REQUEST	Current Zoning: CC, commercial center Proposed Zoning: CC, commercial center, site plan amendment
LOCATION	Approximately 3.35 acres located on the west side of Johnston Road between North Community House Road and Toringdon Way.
CENTER, CORRIDOR OR WEDGE	Center
SUMMARY OF PETITION	This petition seeks to modify a previously approved commercial center. This proposal seeks to allow increase in size that was already approved. The plan shows the development of a 42,000 square foot fitness center.
STAFF RECOMMENDATION	This petition is consistent with adopted land use plans and policies. Upon correction of the outstanding site plan issues Staff is recommending approval of this petition.
Property Owner Petitioner Agent/Representative	NRI Communities Urban Active Fitness Robert Young
Community Meeting	A community meeting is required the report has not been turned in yet.

PLANNING STAFF REVIEW

ILLUSTRATIVE SITE PLAN
DATE: 07.22.08
SCALE: 1" = 40'
JOB NO. X8032.00
SHEET: RZ-1

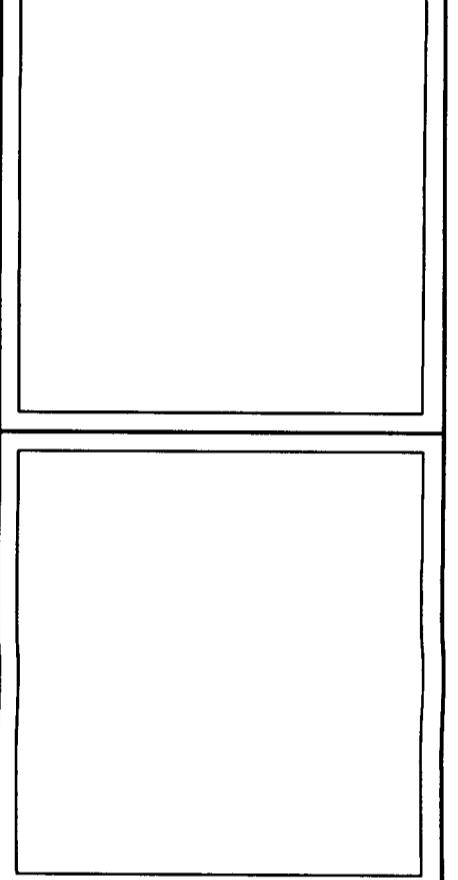
1. The Petitioner should note that bicycle parking will meet the minimum ordinance standards.
-
